CITY OF ALBUQUERQUE

January 20, 2026

Re: Dunkin Restaurant
310 Avenida Cesar Chavez SW
30-Day Temporary Certificate of Occupancy
Transportation Development Final Inspection
Engineer's Stamp dated 08-06-24 (L14-D002)
Certification dated 12-17-2025

C1.1

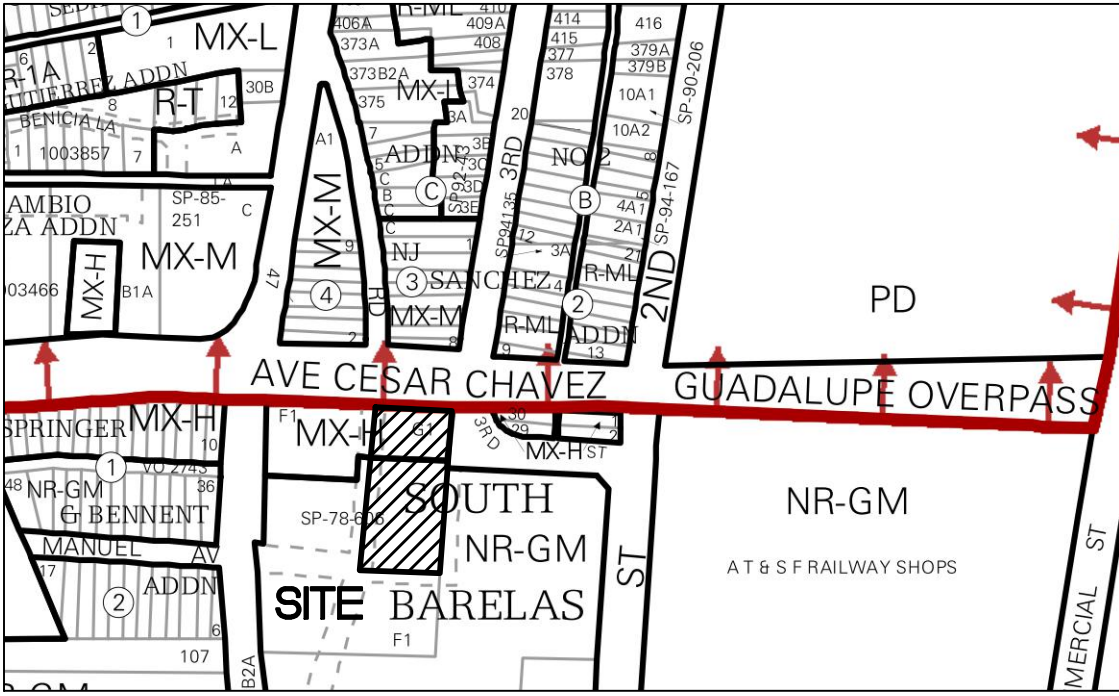
- Keynote 14: a "DO NOT ENTER" sign must be installed at the exit of the drive-thru.

Once this correction is complete, email pictures to malnajjar@cabq.gov for release of Final CO.
